**RE: BP#2016-01319 167 -169 Newbury Street - Preliminary plan review (Foundation only)**

**Subject:** Re: BP#2016-01319 167 -169 Newbury Street - Preliminary plan review (Foundation only)

LS1.1

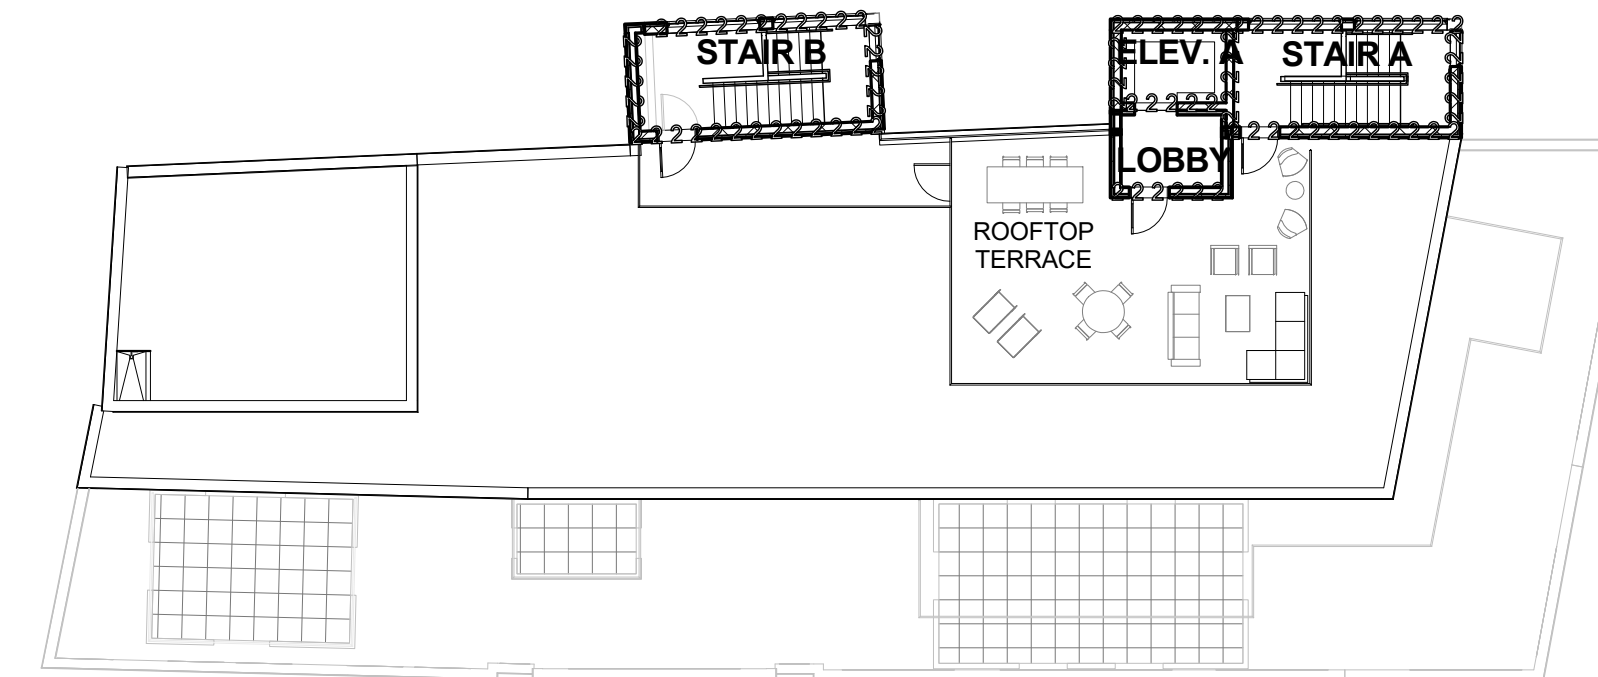
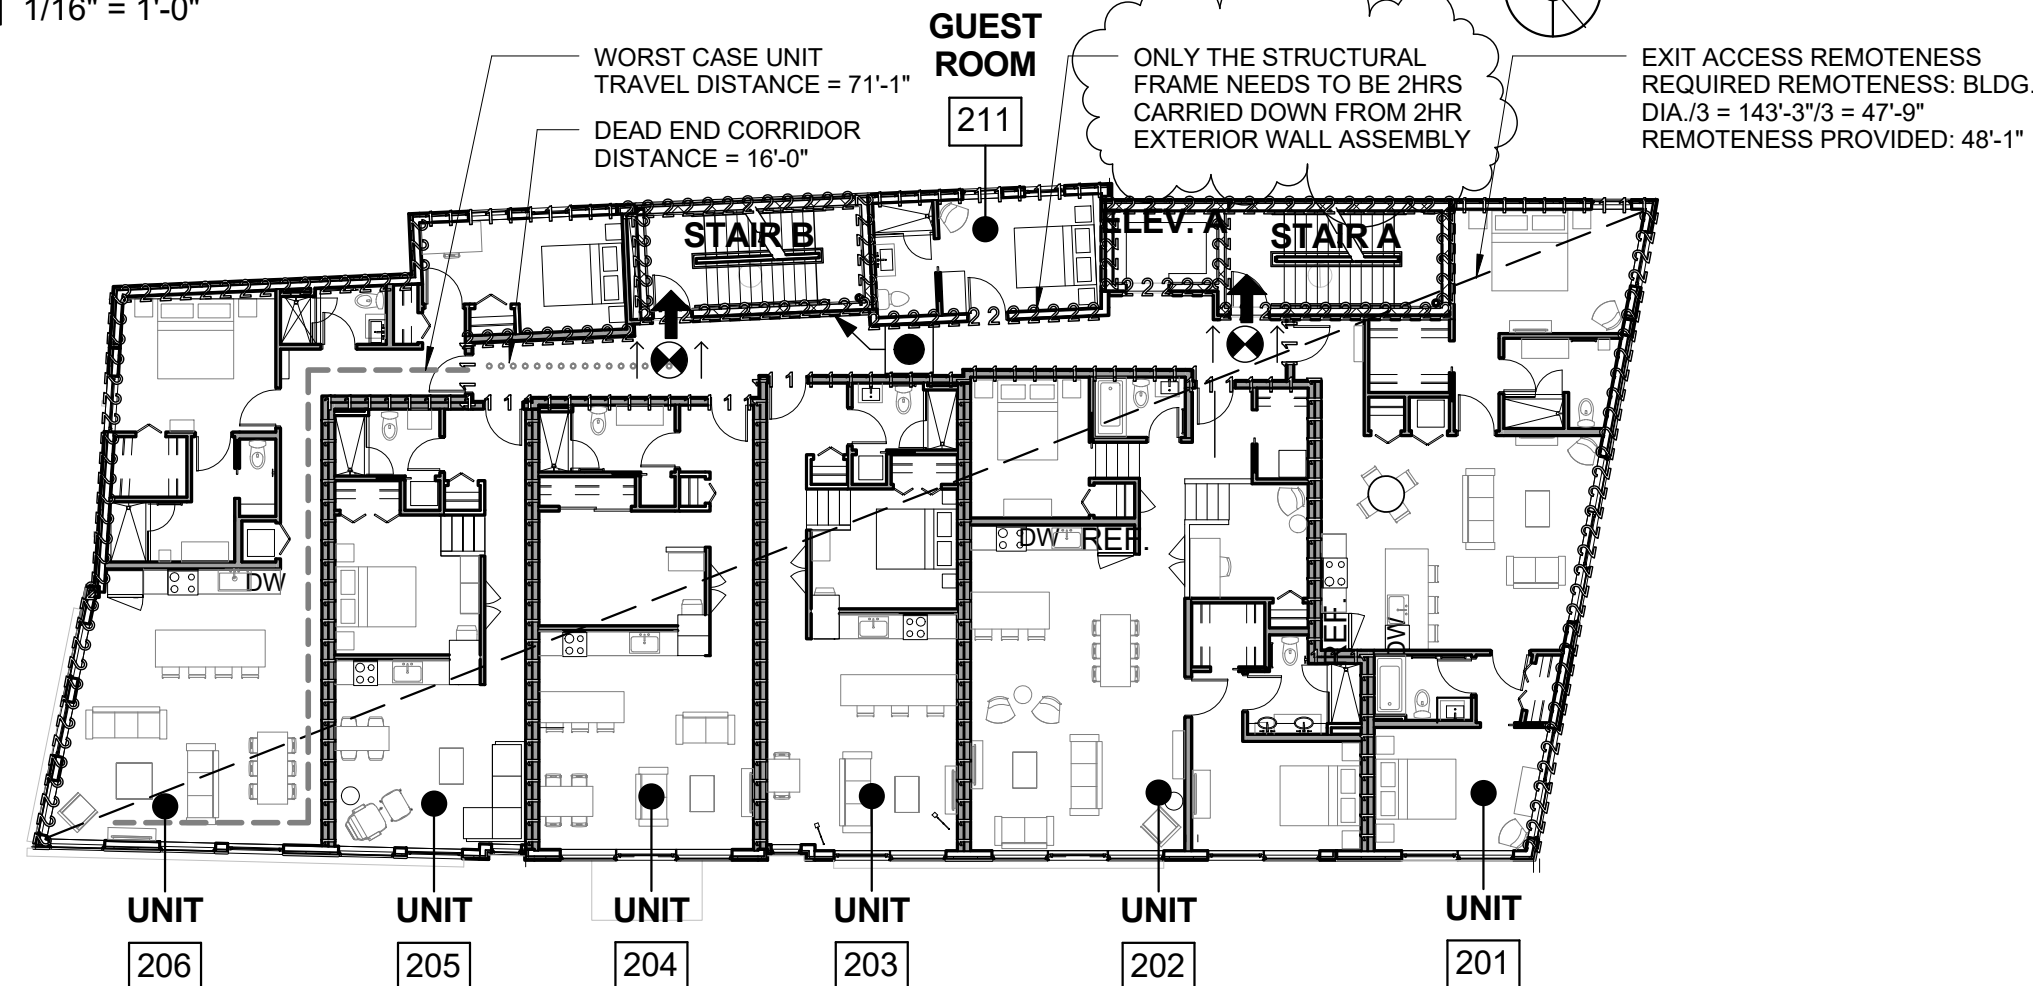
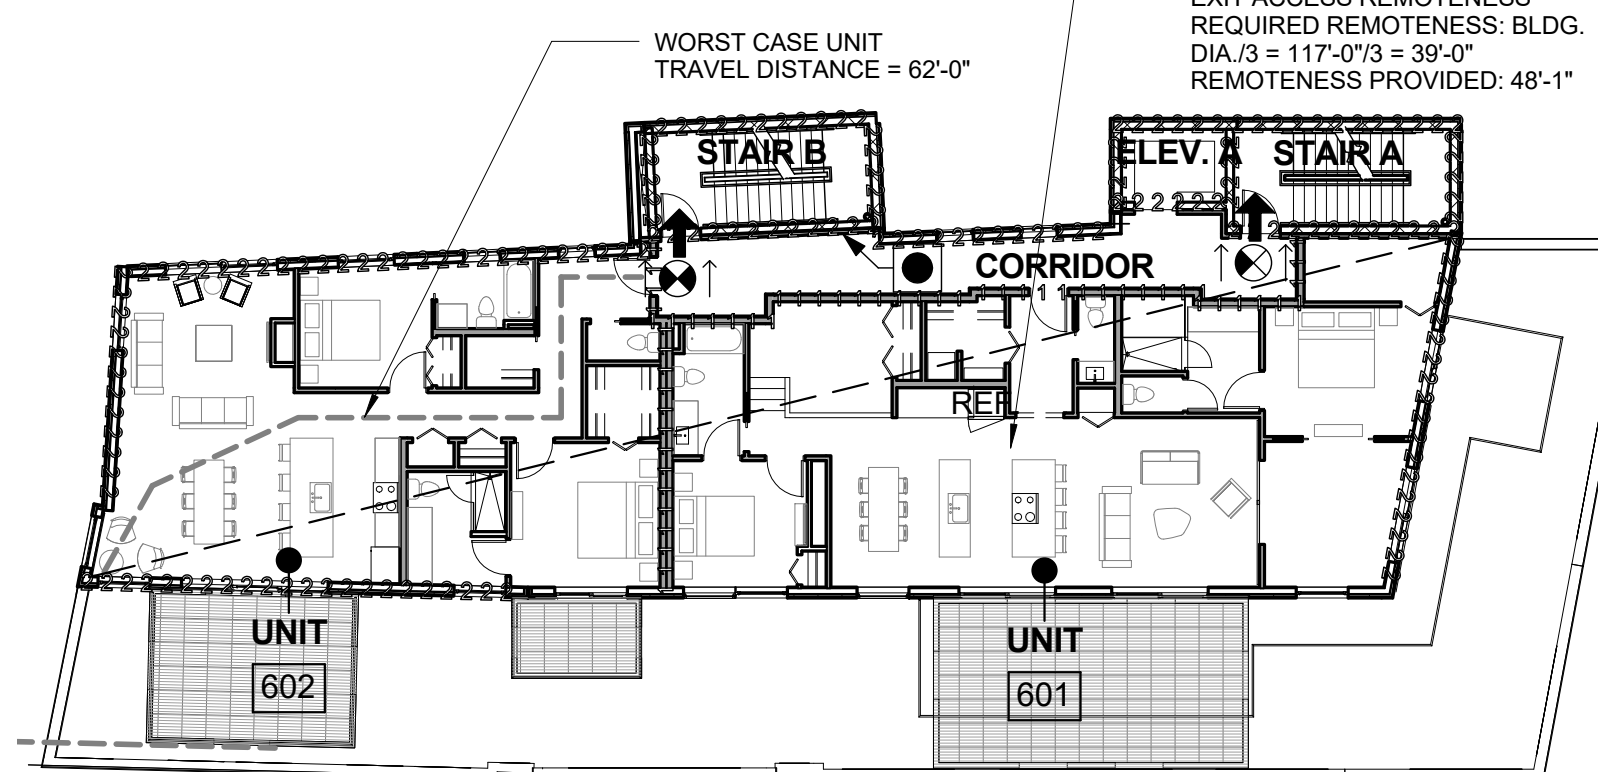
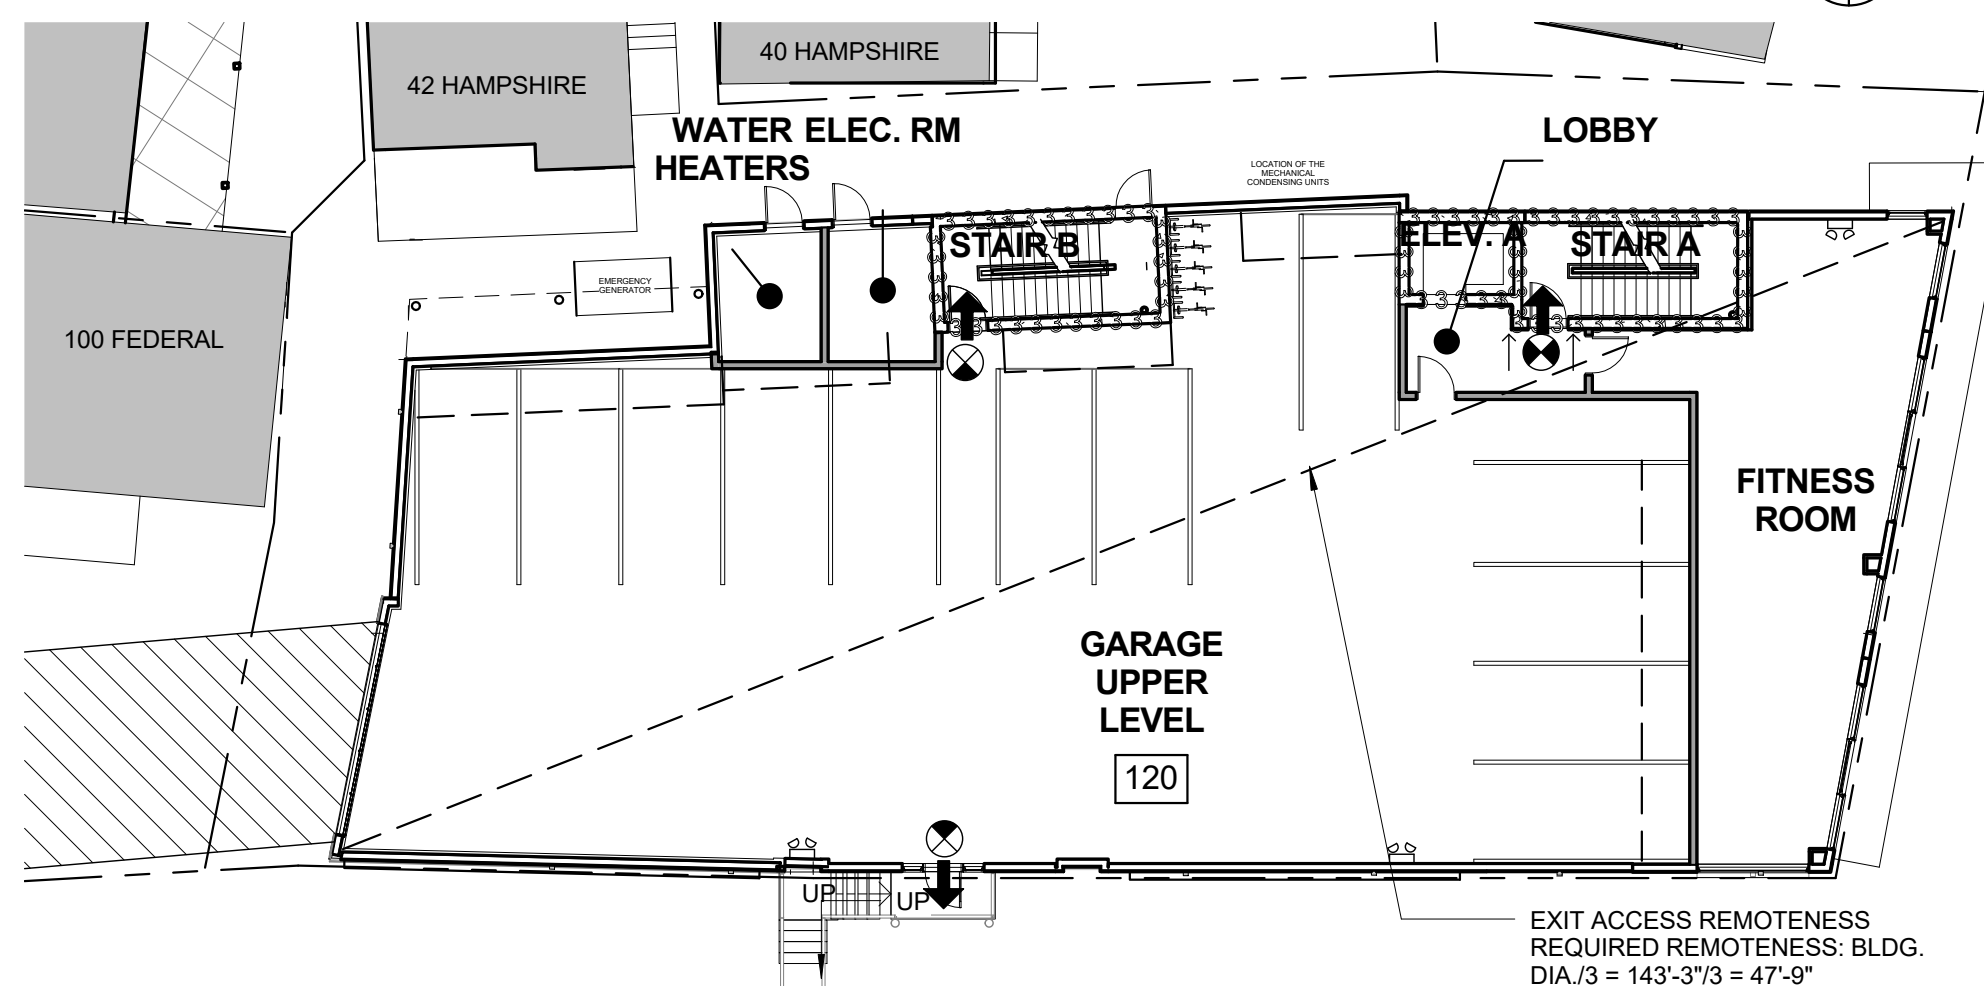
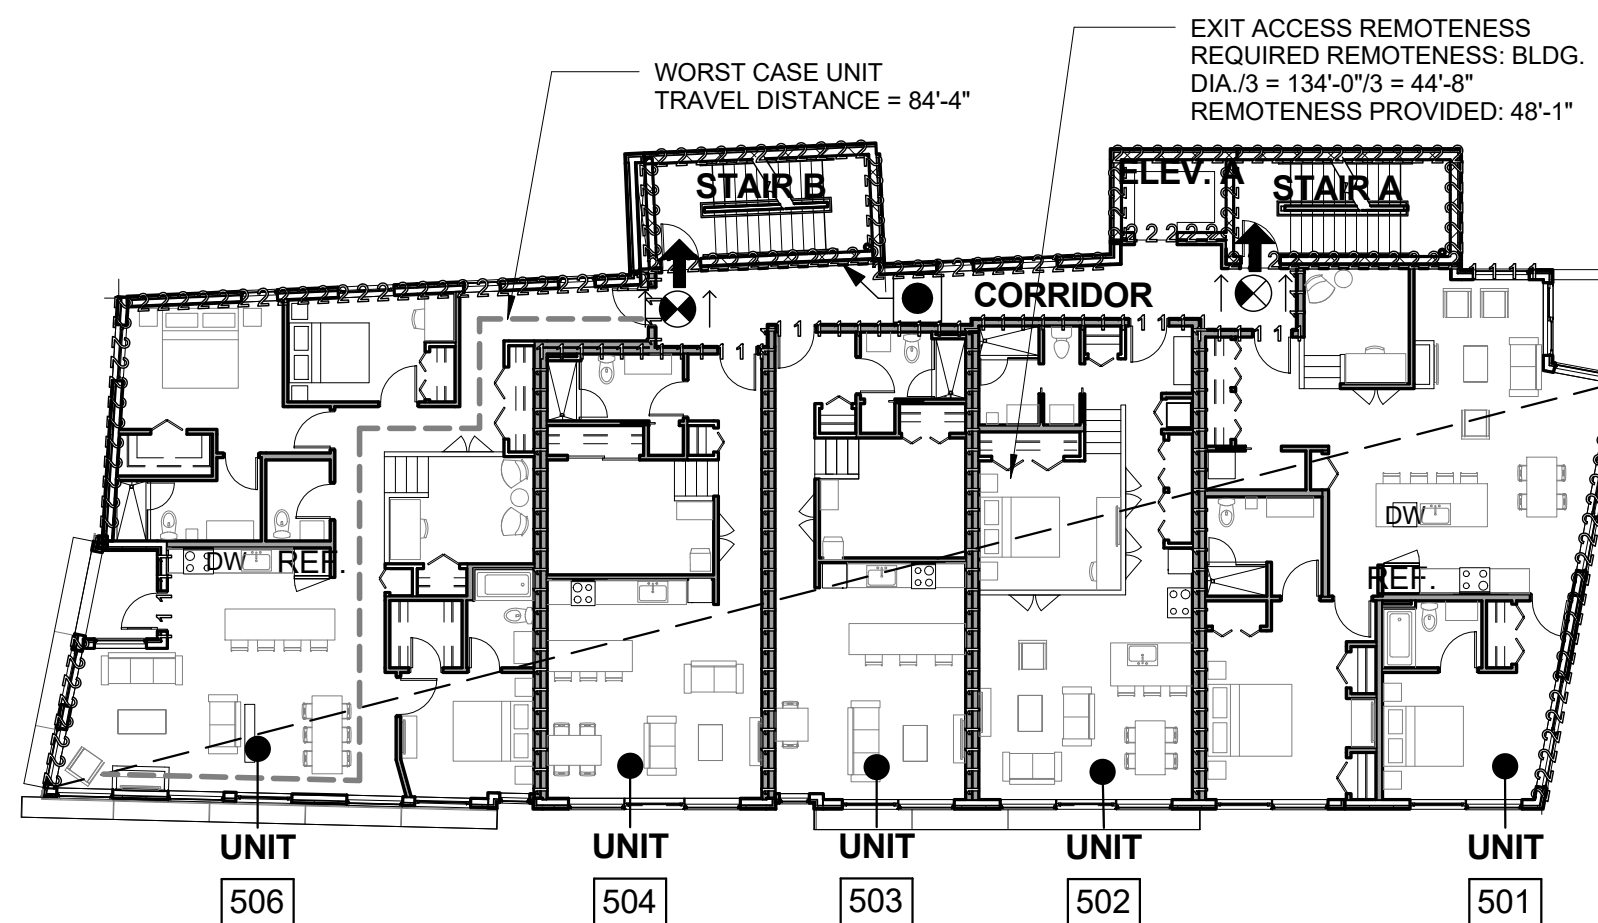
- All plans should be stamped including the code analysis and life safety plan. **The attached code analysis and life safety plan are stamped. I bubbled any changes since the last drawings I sent you.**
- Provide occupant load calculations in the code analysis. **The occupant loads are located in section 1005. I pulled out the fitness room as a separate occupancy (I clouded this section so it is easy to find)**
- The fitness center on the first floor looks to be greater than 10% of the floor area. Clarify how you justified this being an accessory occupancy. **You are right that the floor area is greater than 10%. I pulled the fitness room out of accessory occupancy and created it as separated use. Per table 508.4 we don't need any separation between the garage S-2 and fitness room A-3.**
